From: Laura Gibbons
Sent: 28 August 2018 14:25
To: Simon Davis
Subject: RE: Land to the rear of 41-47 Pevensey Road BR/229/17

Laura Gibbons, MEng, GMICE
Engineer (Drainage & Coastal)

Typical ground floor/ wall detail

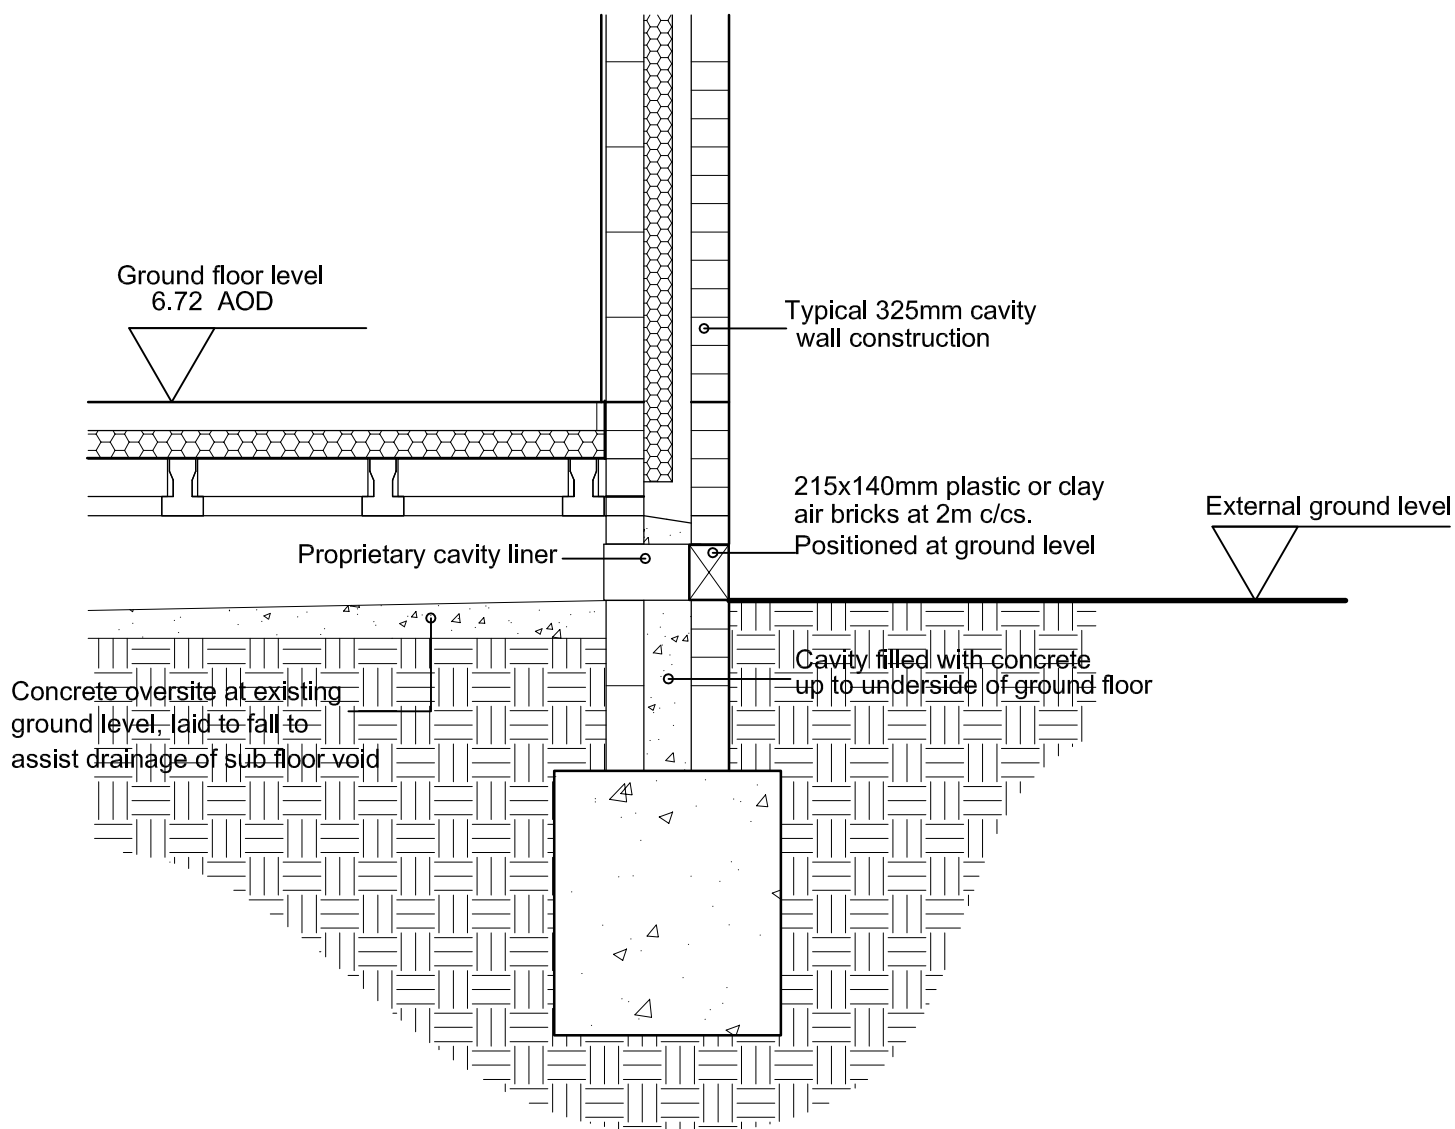
The query I had previously about water going under the house was in the method to facilitate this. Now that the details of how water is to go under the houses have been provided I have been able to give further comment.

Water can go under houses in floating house design for example. Or if the foundations were to be piled and the house set up on columns. Both of these options still have problems with then confined space working to clear out the sub floor area afterwards, but at least they don't leave contaminated water/debris under a house and they won't require the building floors/ interiors to be ripped apart to deal with the aftermath of flooding.
